# One Earth Solar Farm

**Draft Statement of Common Ground with West Lindsey District Council**

**EN010159/APP/8.4.1**

August 2025

Figure 25: Height parameter plan

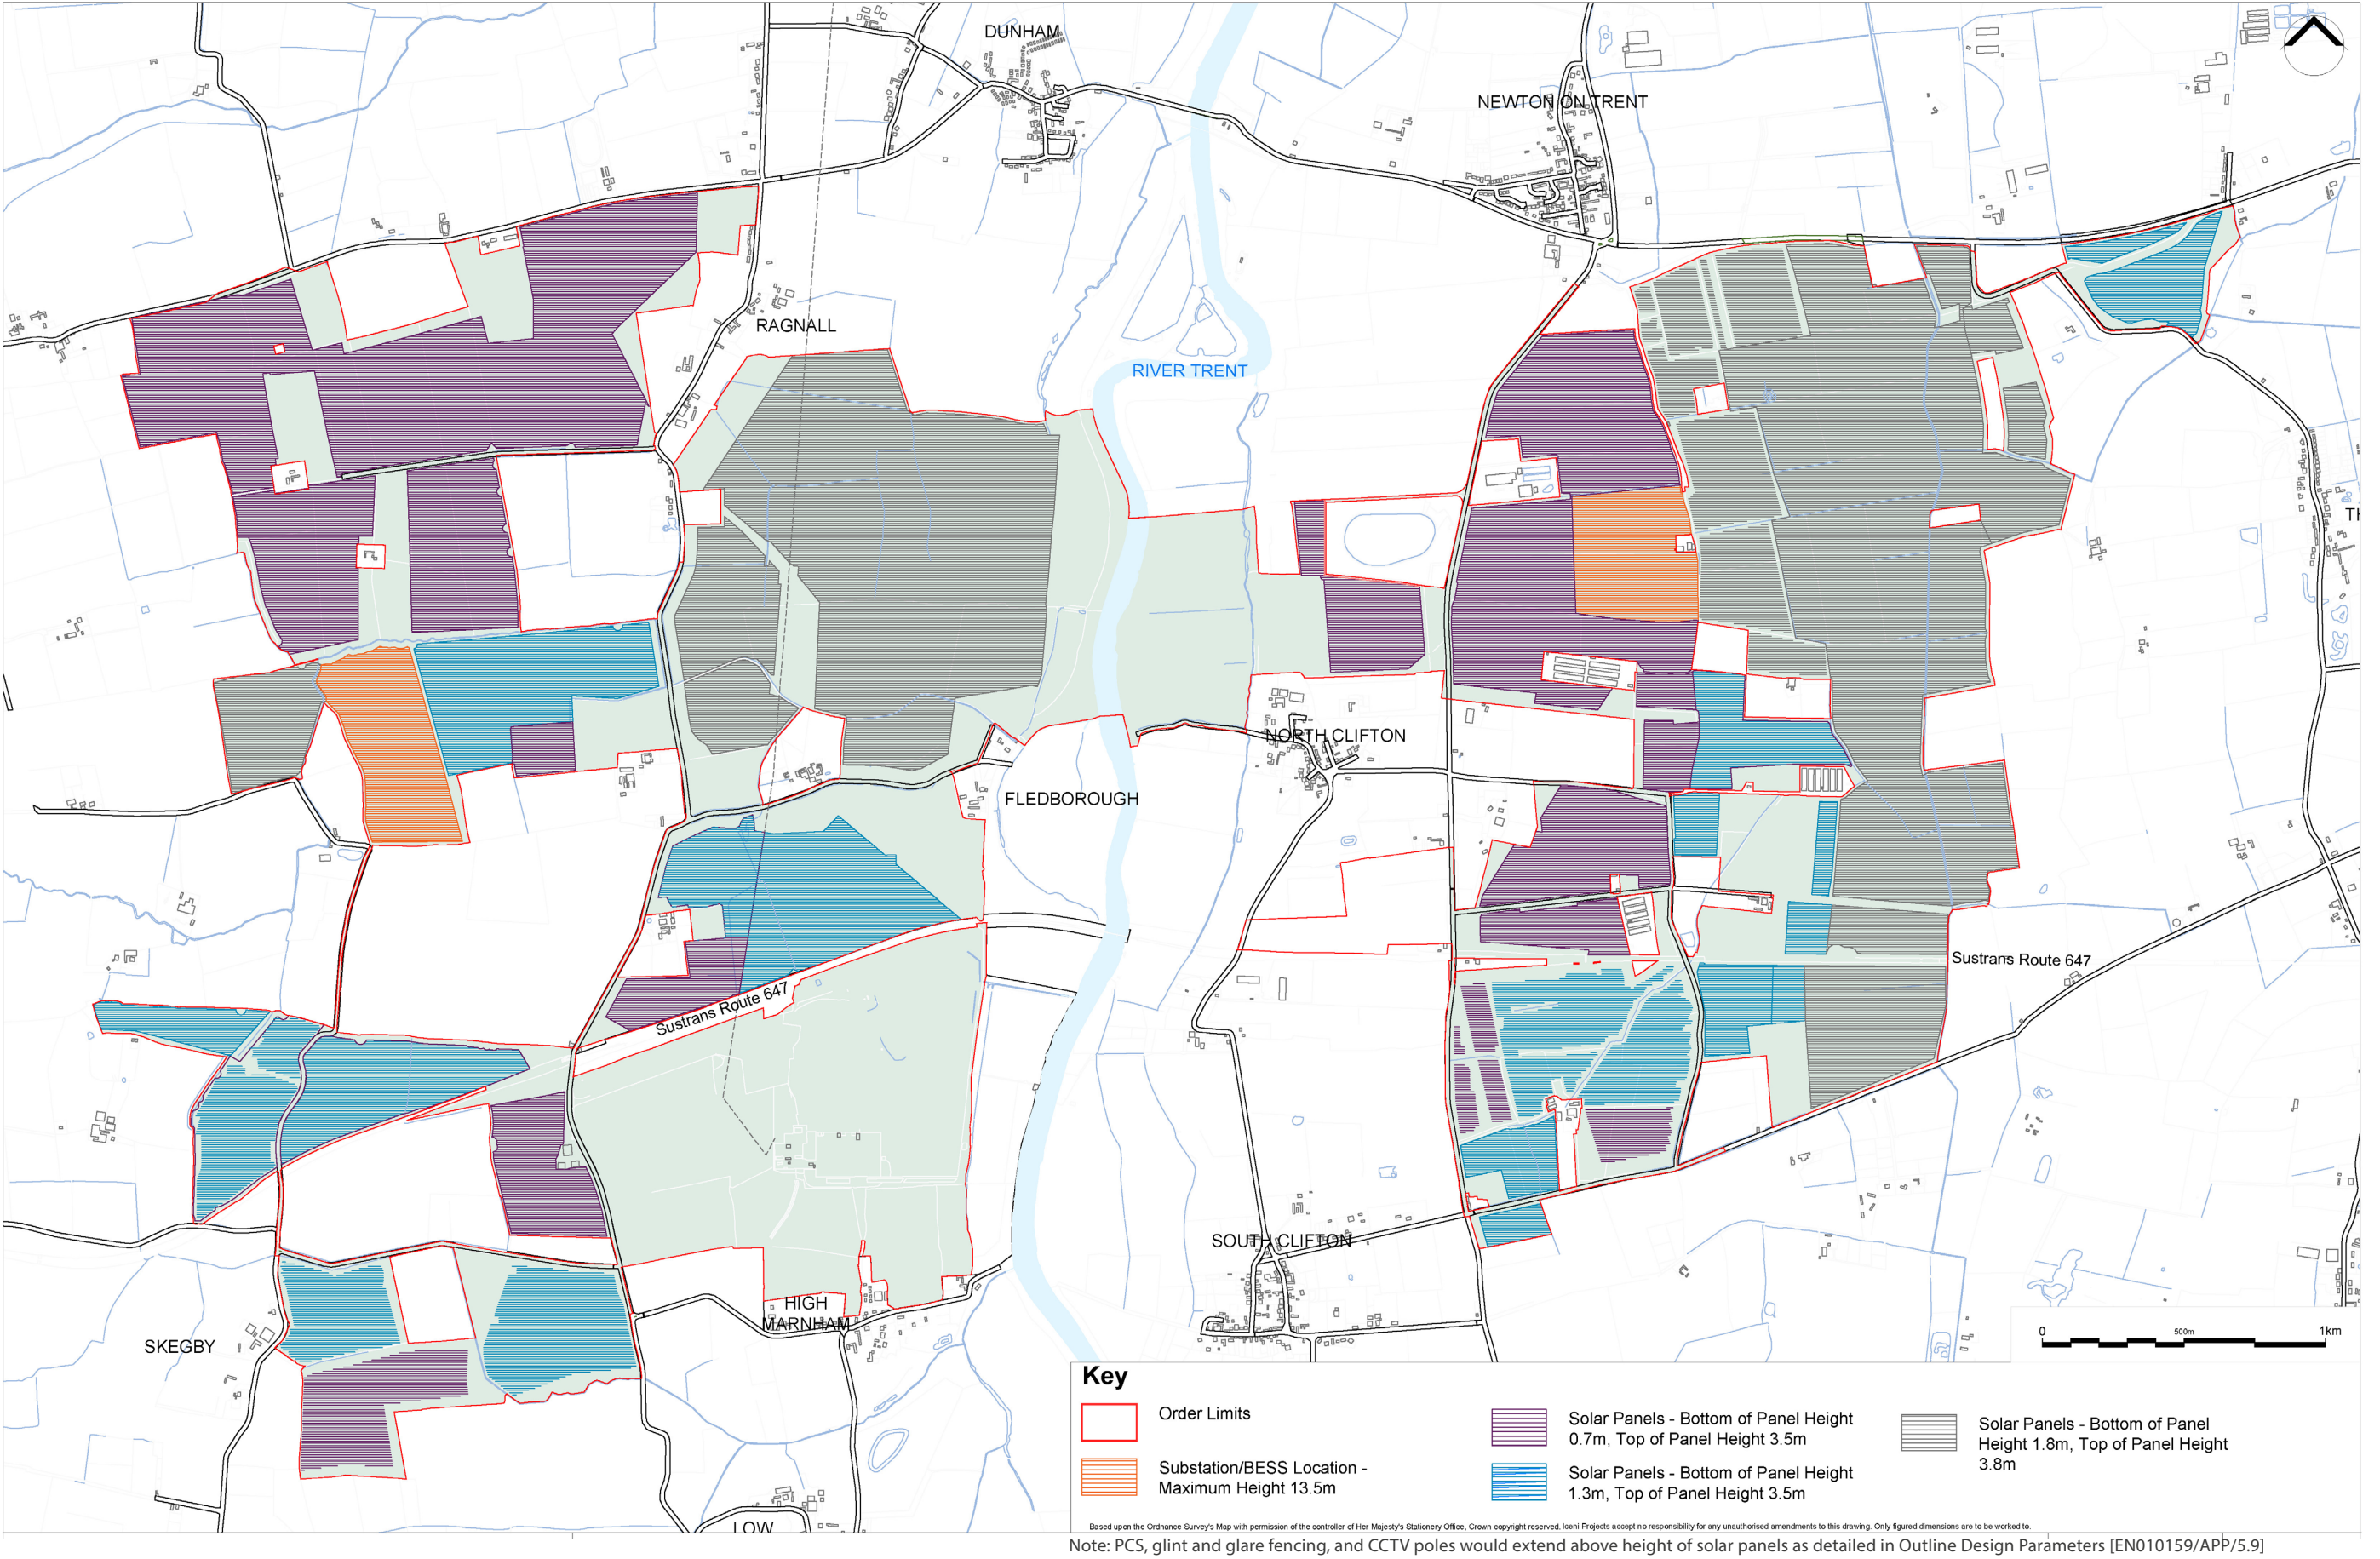
- Outstanding LVIA matters
- Visual impacts on users of A1133
- Design of BESS and substation
- Glint and Glare mitigation fencing

- WLDC to review and update position on LVIA matters
- Applicant to clarify how the height of the substation and BESS will be distributed across the Work Areas.

this area being selected as the optimal location for this type of development		
08-02	Design Approach	<p>The design approach applied to the OESF project has resulted in the siting of large-scale infrastructure in the form of the substation and BESS being located in conspicuous and highly visible location within the West Lindsey District. The eastern BESS area is identified on the height parameter plans [APP-016] as having a maximum height of 13.5m. It should be noted that, according to plans submitted by Anglian Water for the works currently being undertaken at the Hall Water Treatment Works, immediately northwest of and adjacent to the eastern BESS area, the current main (and highest) building on the water treatment works site is approximately 10m in height to its ridge. This is currently the highest structure for some considerable distance. Assuming the 13.5m maximum height indicated on the plans will extend across the majority of the BESS area, the BESS area would be a major new element in the countryside, akin to distribution warehousing.</p>	<p>The Applicant has continually sought to embed good design into the project, and evidence of this is provided in the Design Approach Document [AS-013].</p> <p>The Applicant disagrees that the substation and BESS are located in a conspicuous and highly visible location. The Applicant judges that the visual impact of the Proposed Development as a whole would be localised in the landscape. This is supported by the conclusions of Chapter 11 [REP1-025] which finds that significant visual effects would be mostly experienced by people within or immediately adjacent to the Order Limits and no significant effects are predicted beyond approximately 200m of the Order Limits.</p>	<b>Under discussion</b>
